**TITLE:** REVIEW OF TRIMM AND POSTCOVID MODELLING  
SUBMITTED AT DEADLINE 4

**ON BEHALF Of:** NATIONAL HIGHWAYS LIMITED

**PURPOSE:** DEADLINE 5 SUBMISSION FOR THE LUTON AIRPORT  
EXPANSION DEVELOPMENT CONSENT ORDER

**DATE:** 14 NOVEMBER 2023

Figure 5.1 AM Peak Without Expansion comparison – Updated vs Original

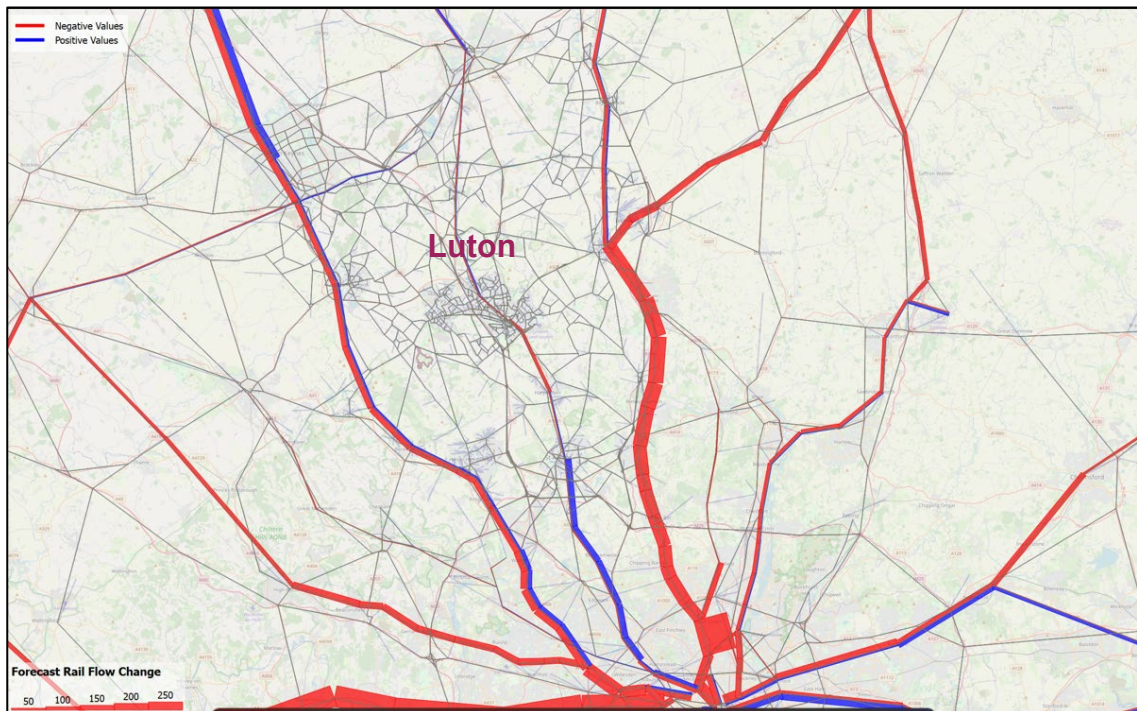
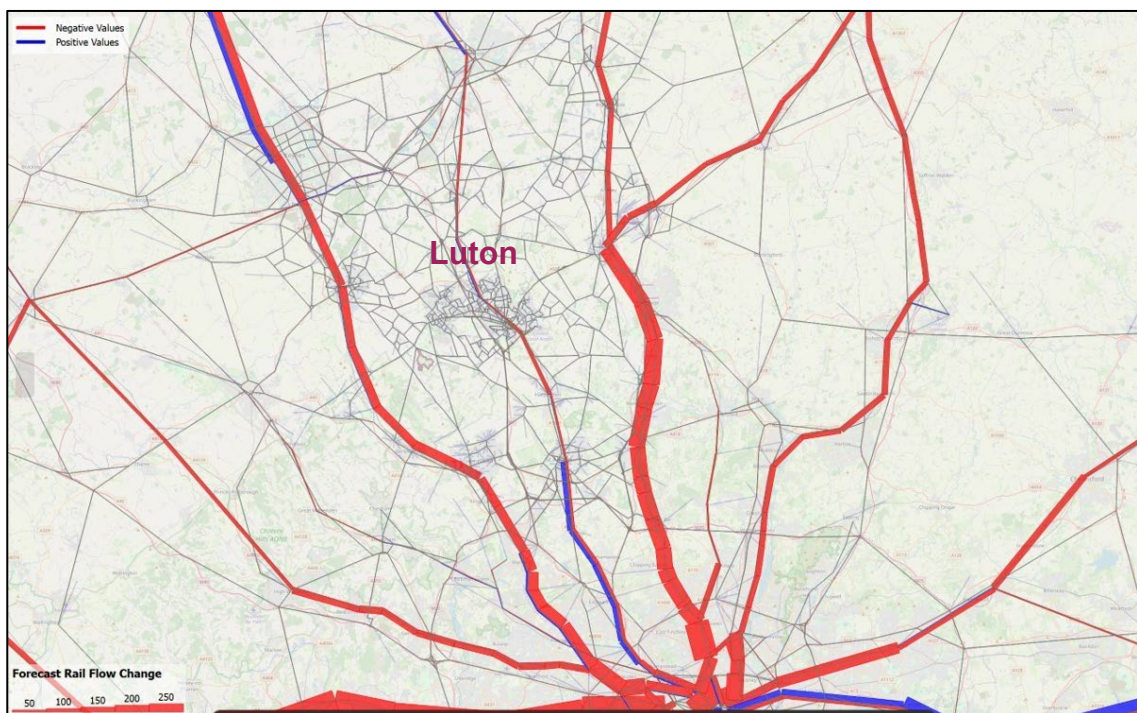
As well as graphical form, the applicant should present the results of Figure 5.1 and Figure 5.2 in tabular form, to see the actual figures. When viewing the figures alone they do not enable National Highways to understand the magnitude/numerical representation of each line on the plot.

Figure 3.4: Indicative locations of survey cameras for traffic distribution survey associated with MT1

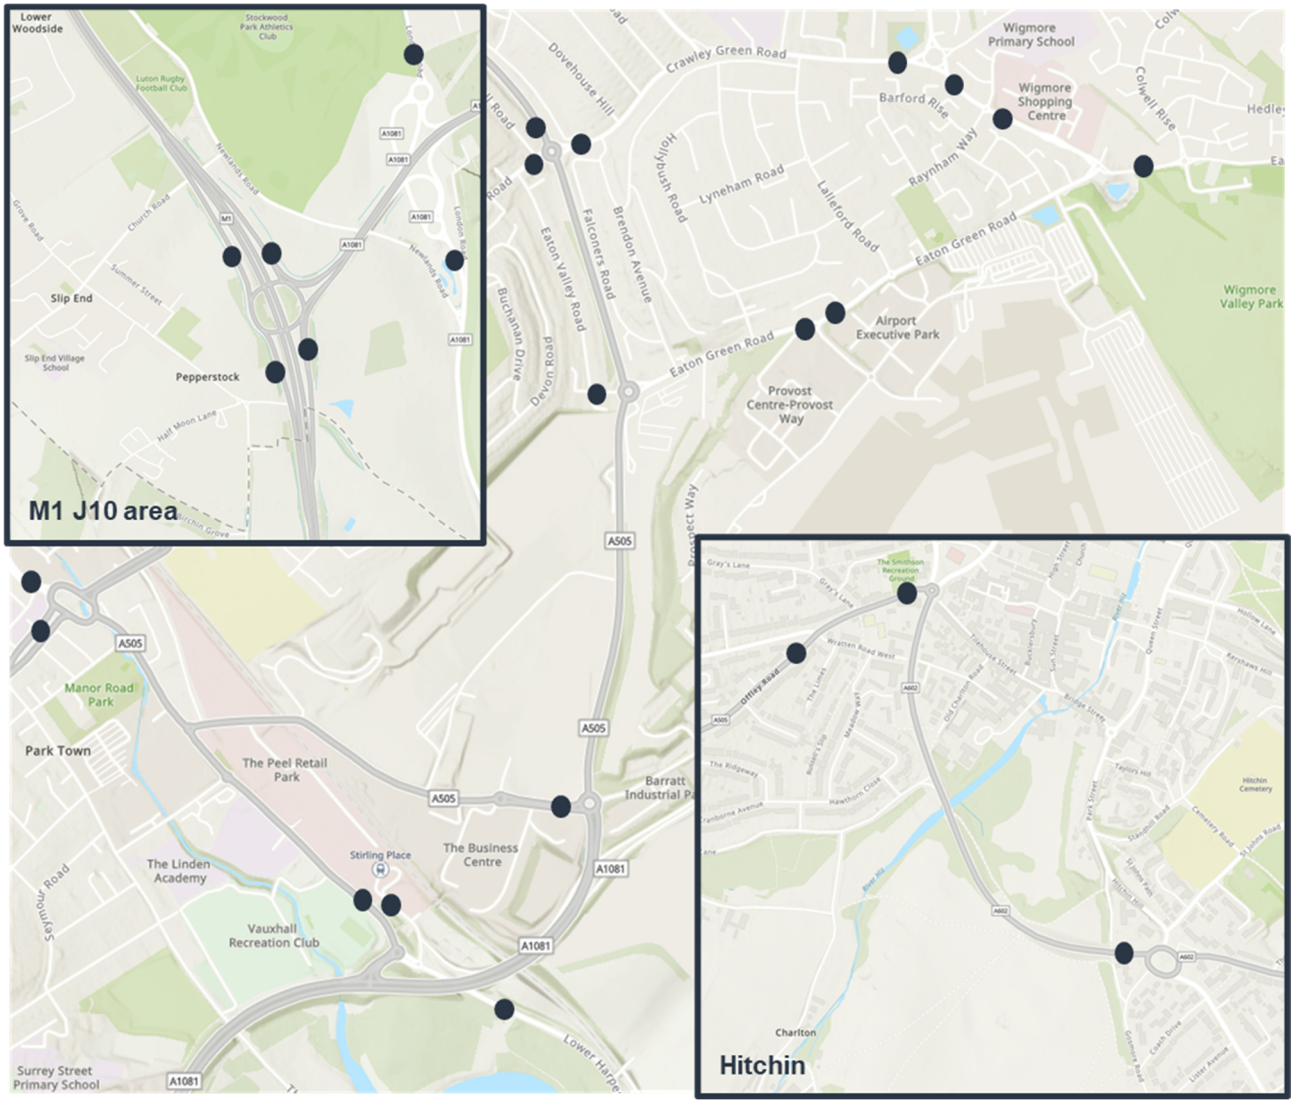
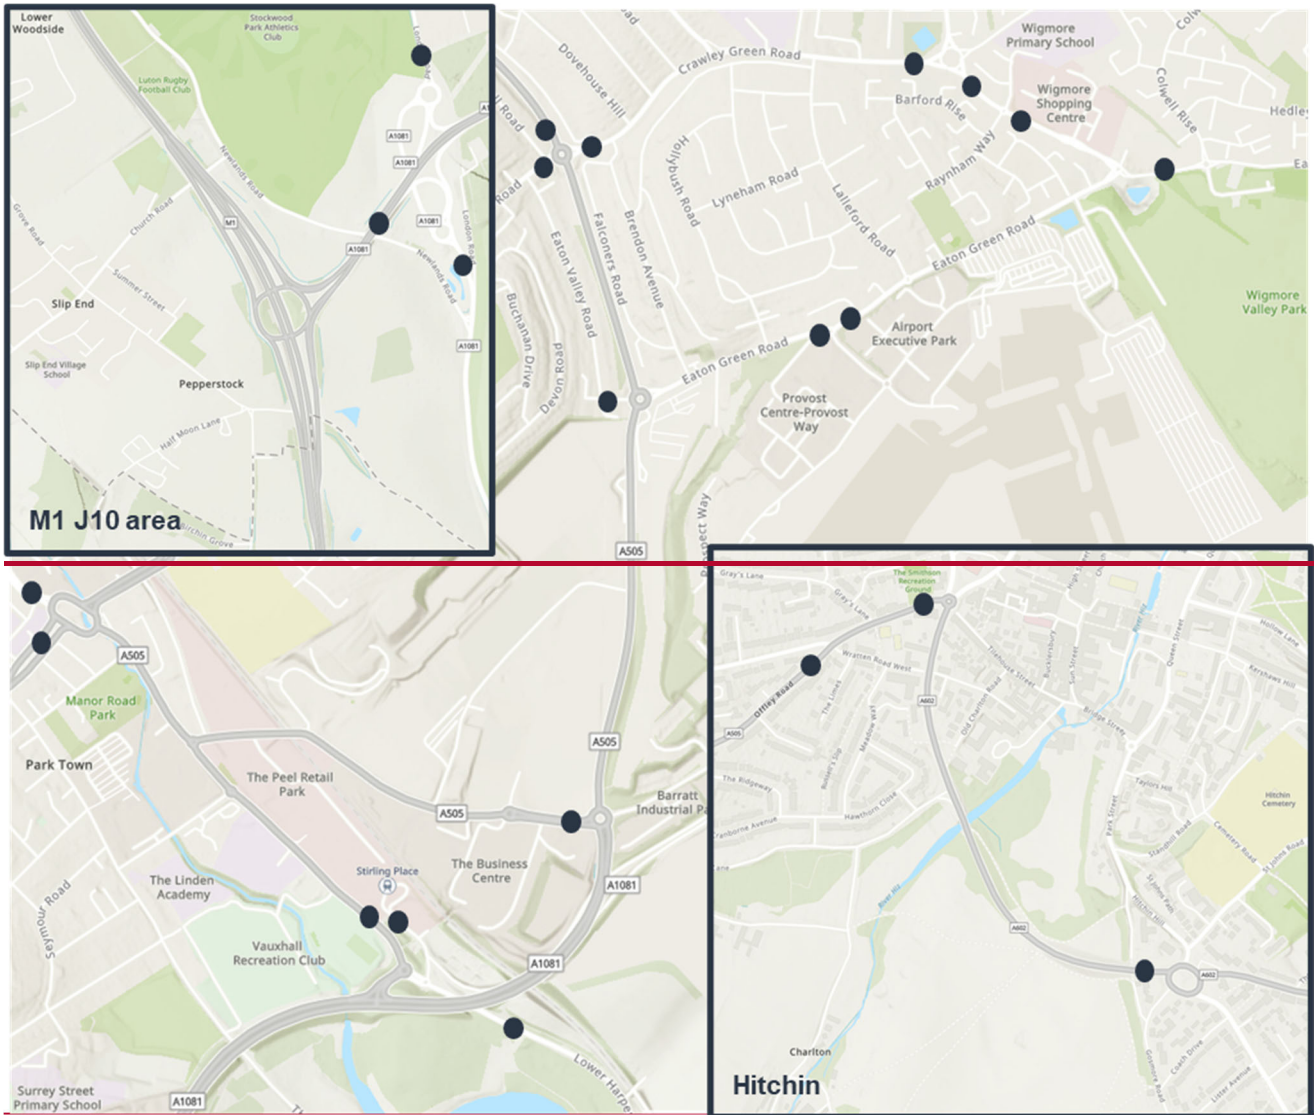
Figure 3.4 in the TRIMMA shows the locations that the traffic monitoring is proposed to be undertaken. For M1 junction 10, one location is proposed on the A1081. Based on this location it is unclear how the Applicant will monitor the capacity constraints and consequences of traffic growth at junction 10 as it will not be possible to determine the movements using each slip/the circulatory carriageway etc to determine when capacity has been reached at the junction. National Highways view is that more detail concerning the junction performance for example turning flows are required given the complexity of movements and potential patterns of congestion at the junction.

The TRIMMA provides a data spreadsheet tool (Section 3.3.8) will assign the airport traffic to the public highway network, based on the distribution derived from the ANPR (or similar) survey located on the A1081. It is unclear how the Applicant will be able to obtain distributional data for M1 junction 10 based on the location of a camera on the A1081. This severely constrains the ability to understand the impacts on junction 10 and the SRN and hence to deploy mitigation.
